READING  
AGRICULTURAL  
CONSULTANTS

**Application No: FG/8/20/PL**

**Proposal: Erection of 1 No. equestrian dwelling & retention of 1 No. gazebo & 2 No. carports**

**Location: Eastlands, Littlehampton Road, Ferring, BN12 6PB**

Title:
Proposed Dwelling

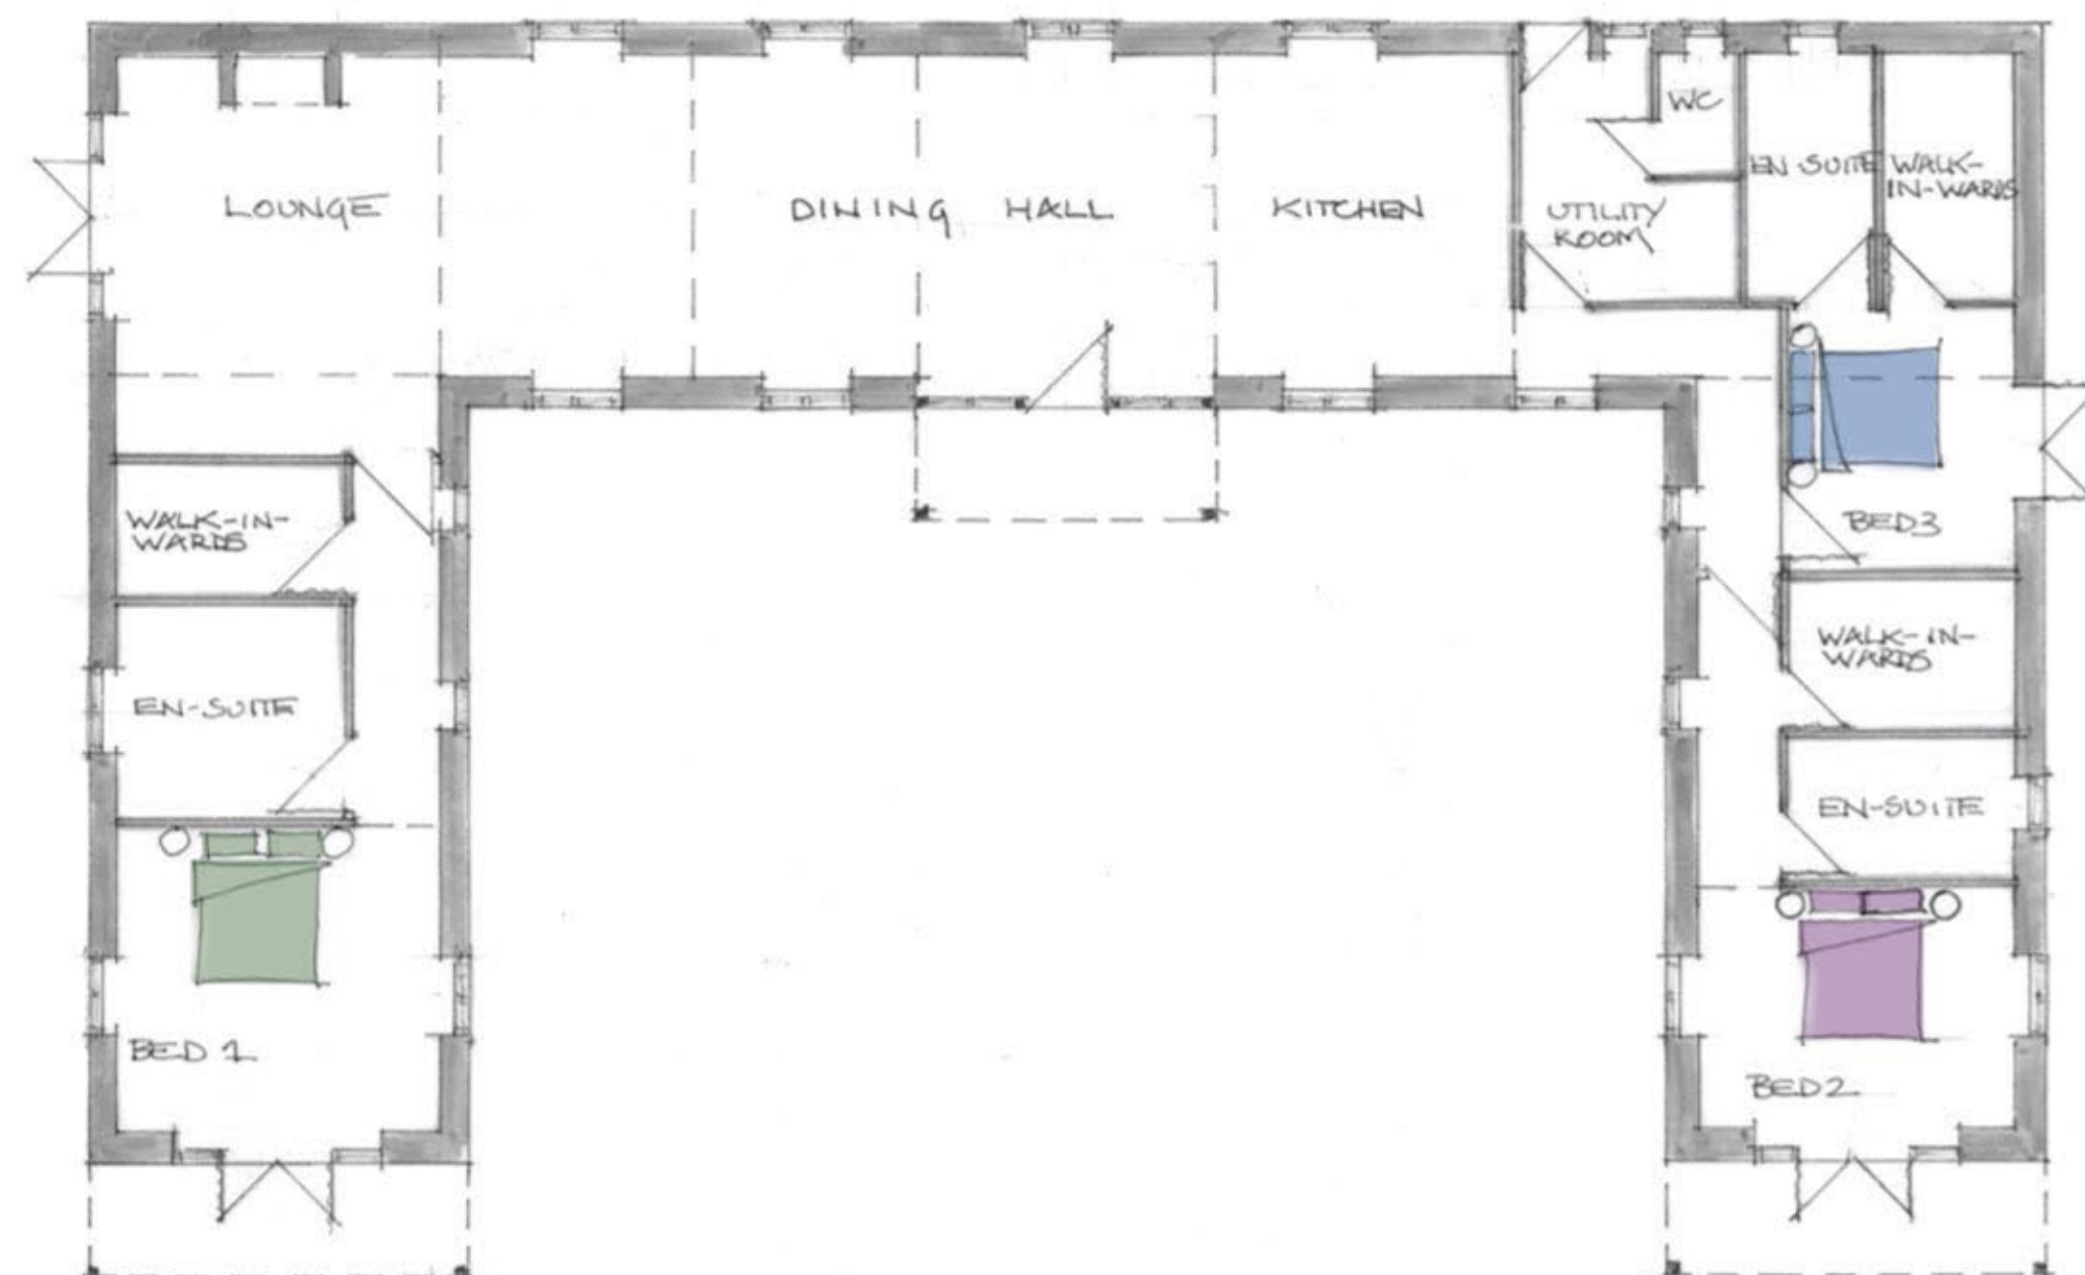
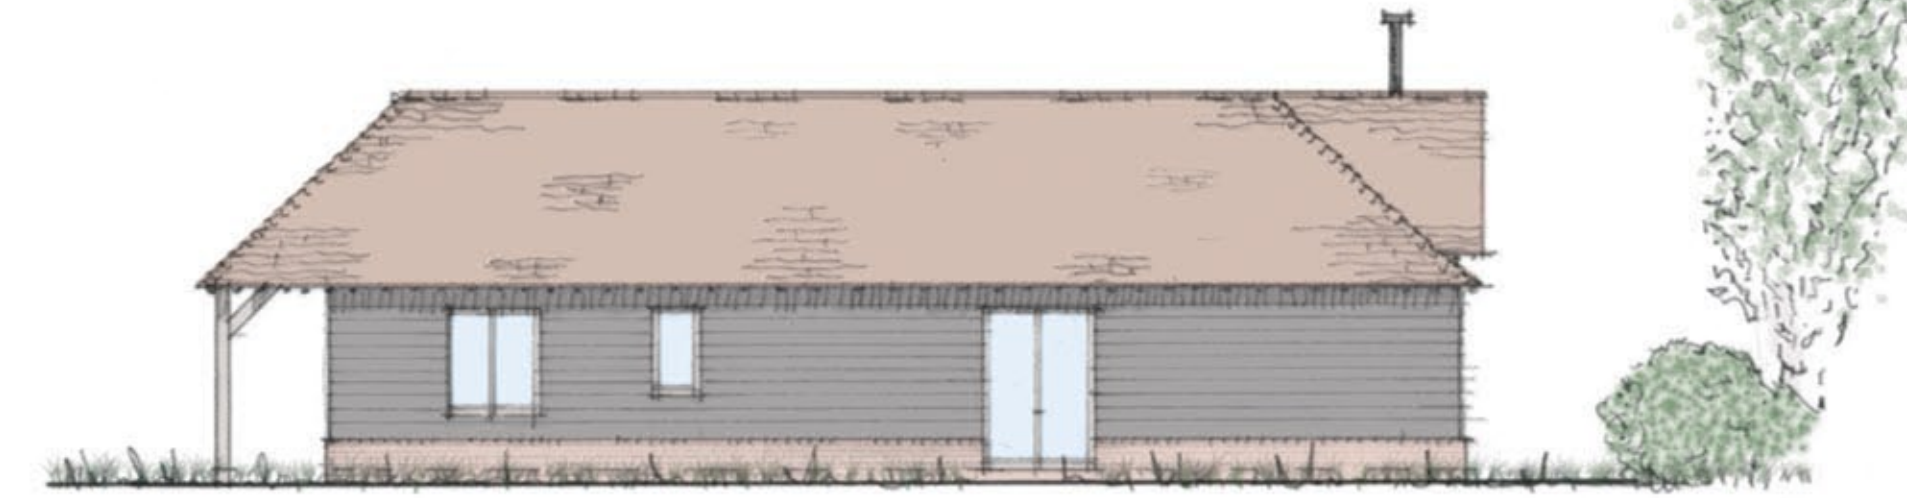
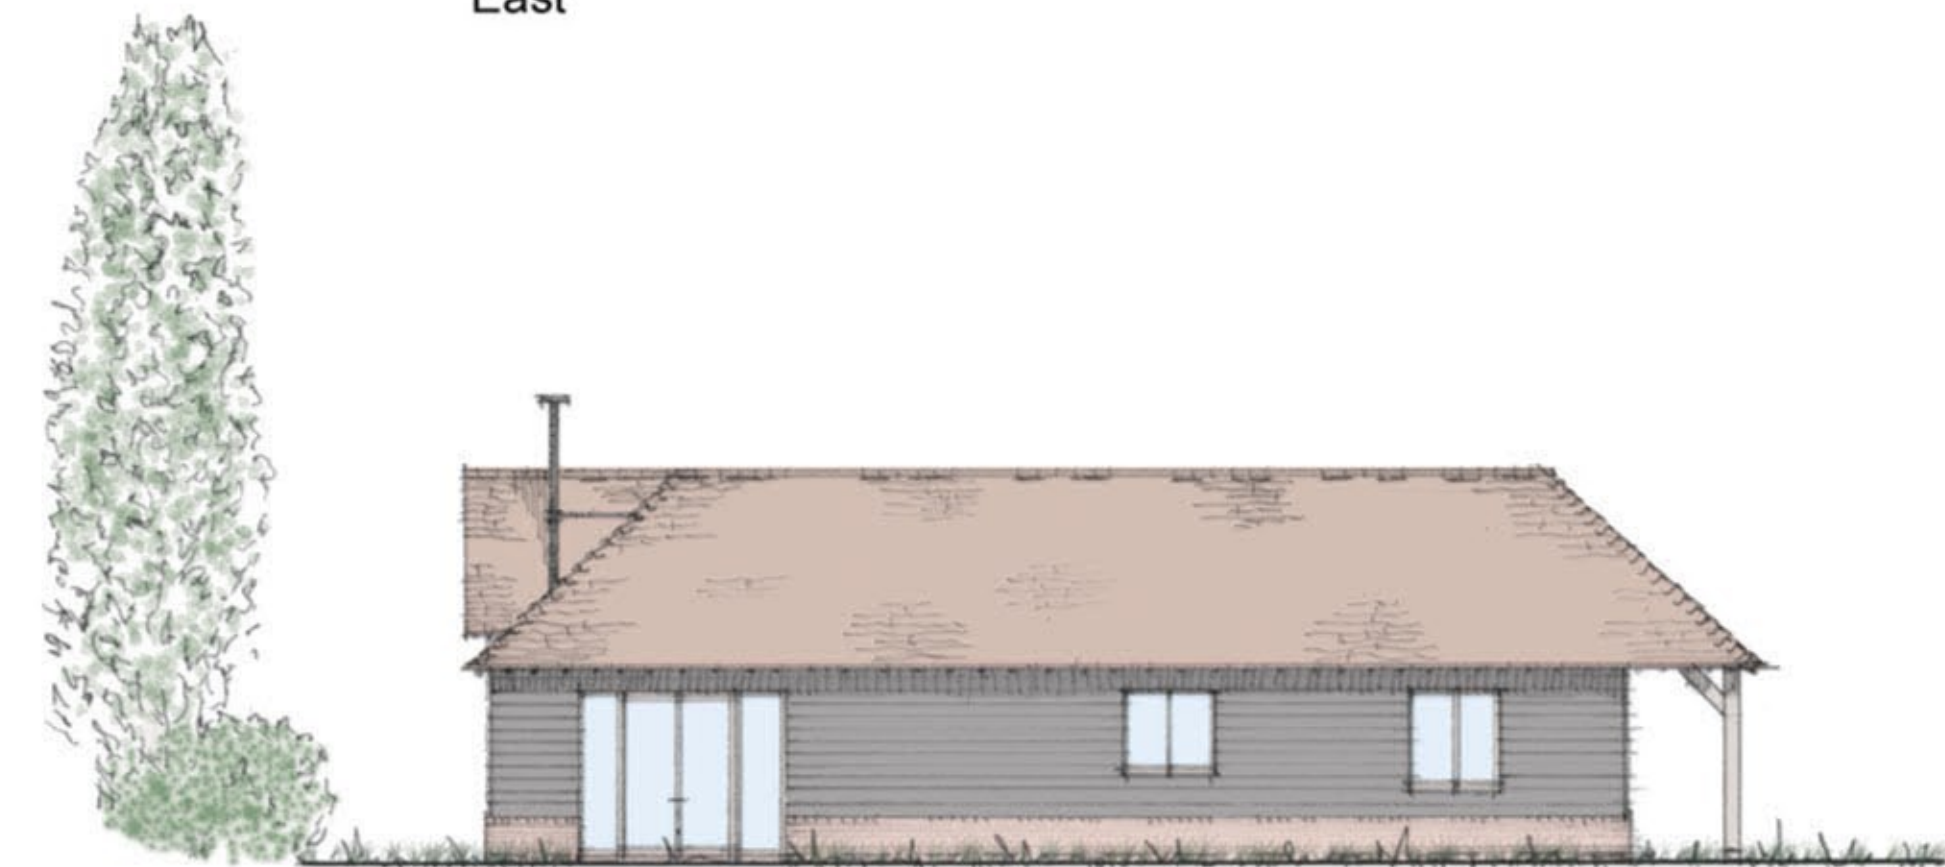
25. The size of the dwelling, with an internal gross floor area of some 180m<sup>2</sup>, whilst large is not unusually large, especially as the Planning Statements notes that part of the house will provide “a spare bedroom for employees, horse owners and/or vets when care is needed through the night”.

Title:
Proposed Site Plan

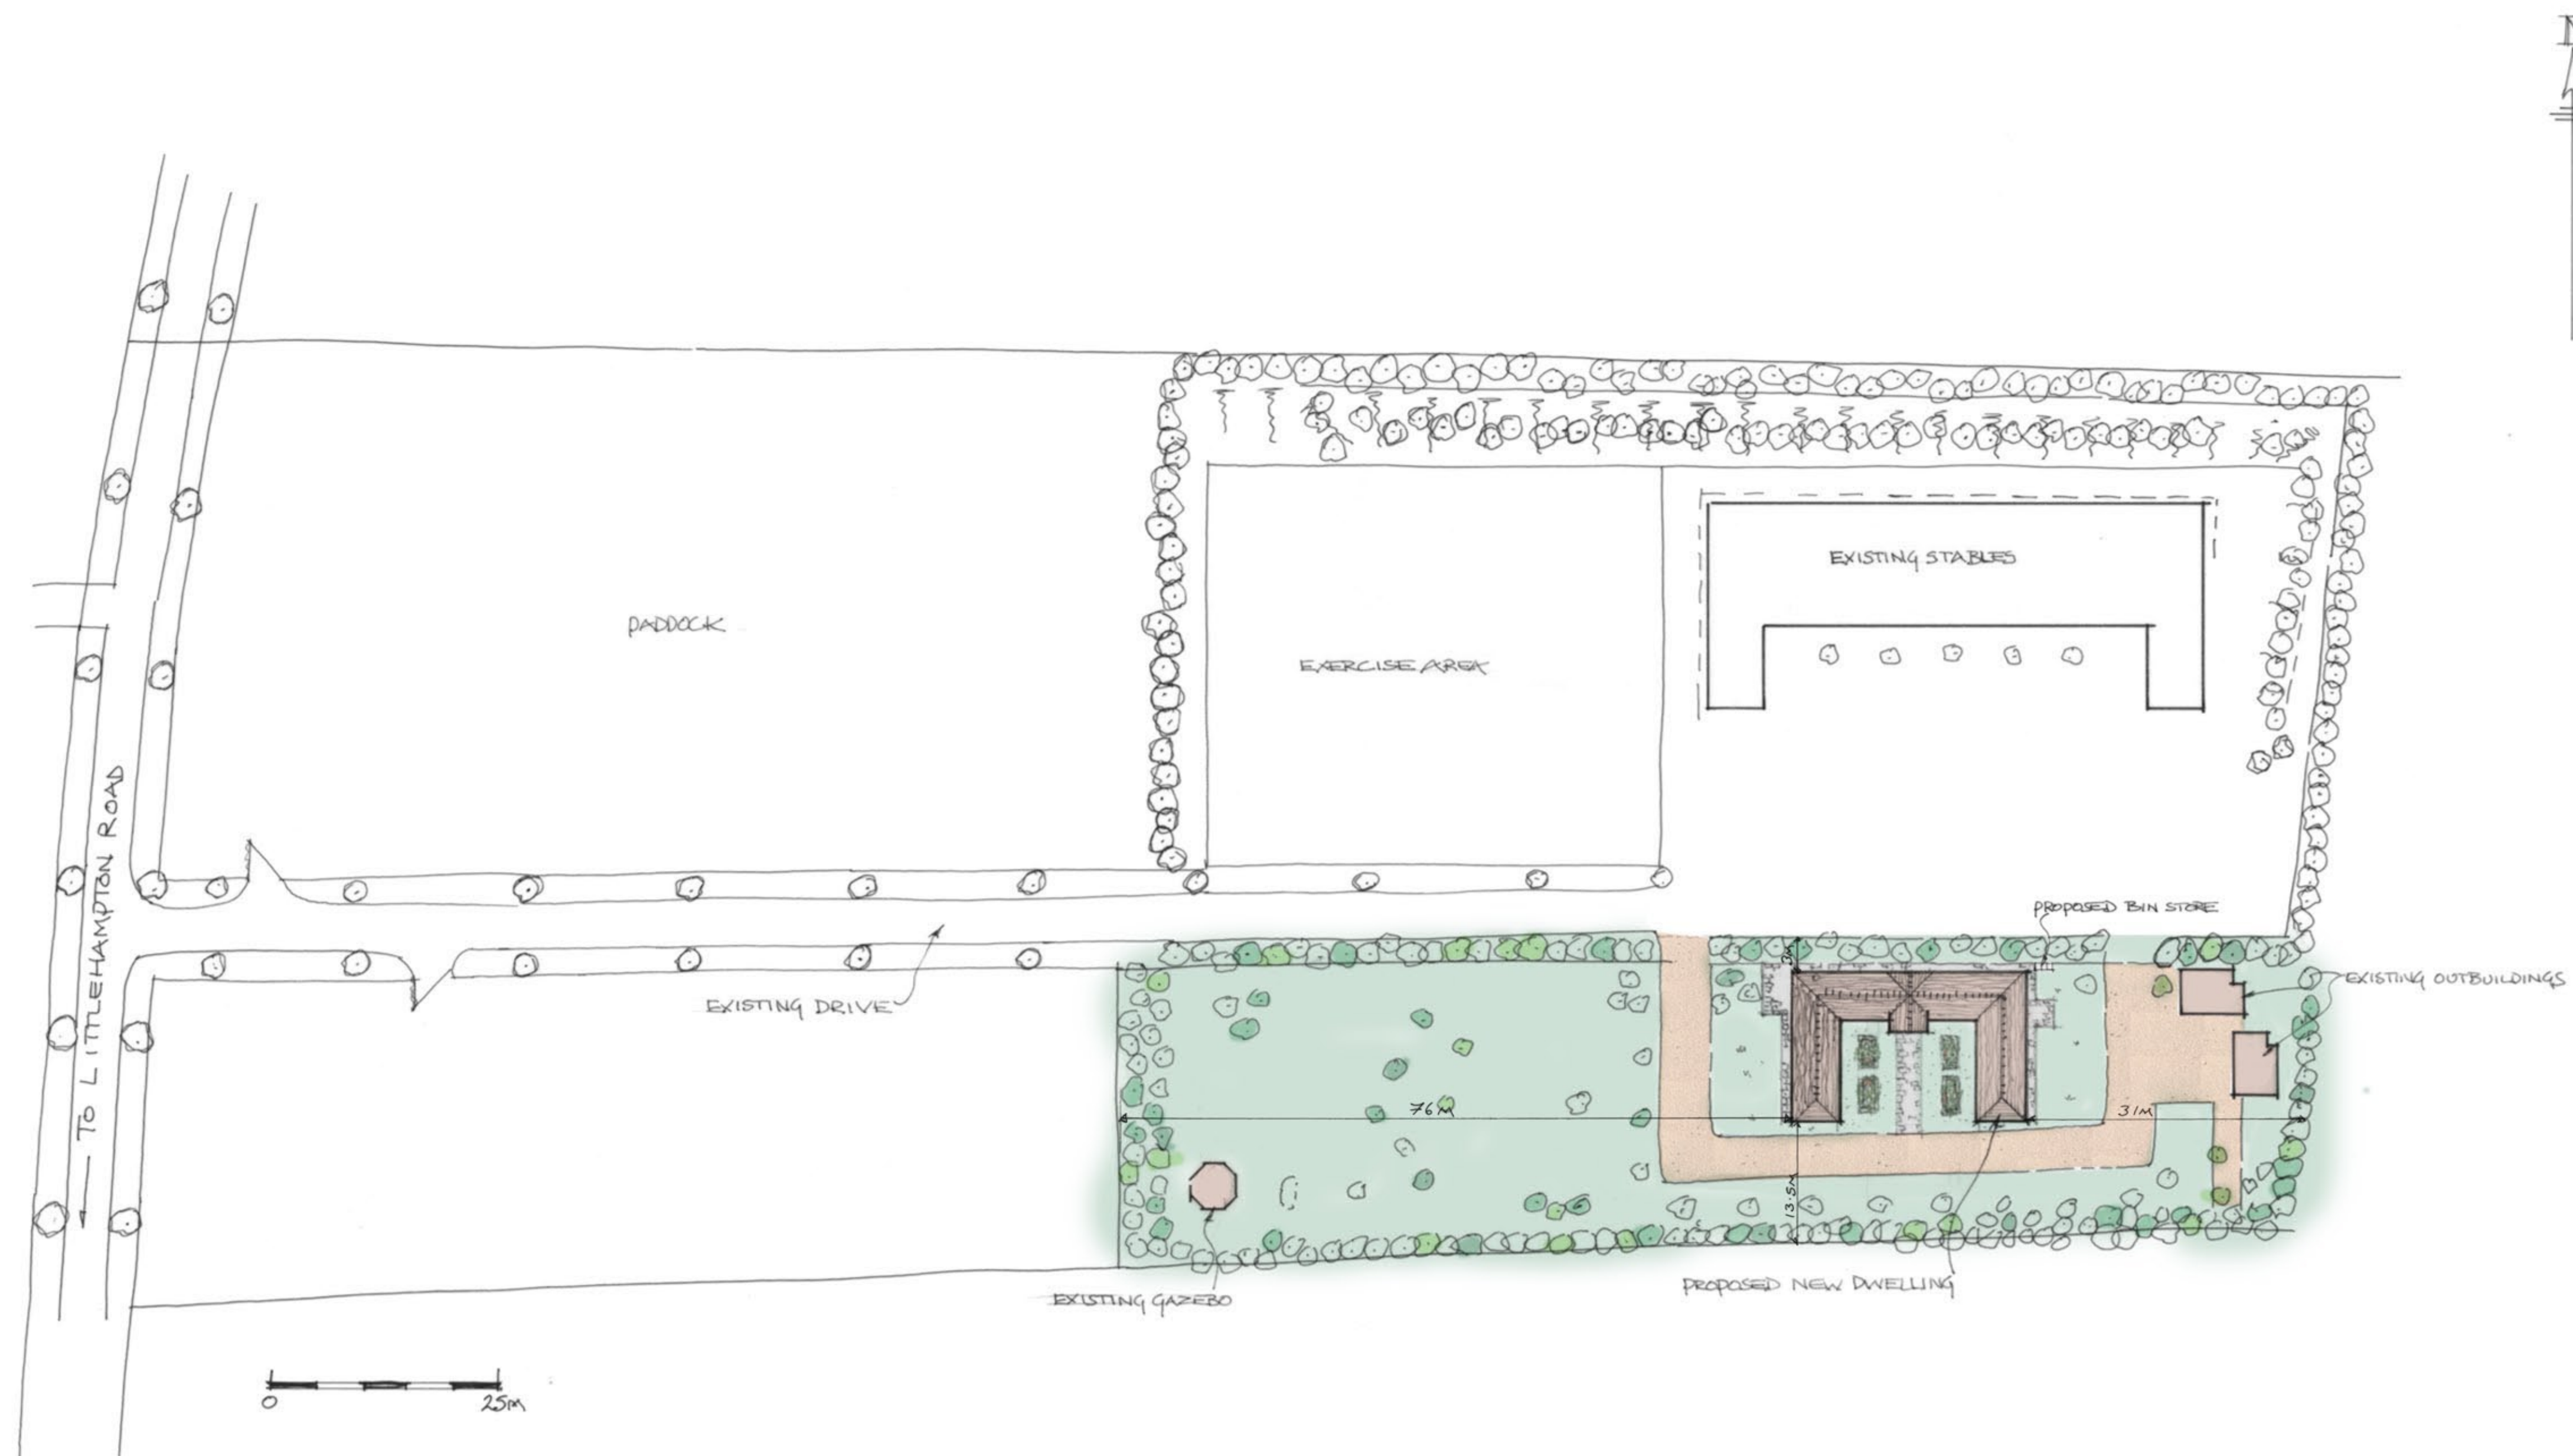
26. The siting of the dwelling is close to the stables and appears appropriate to meet the identified functional need. I trust that these comments assist you in your deliberations.
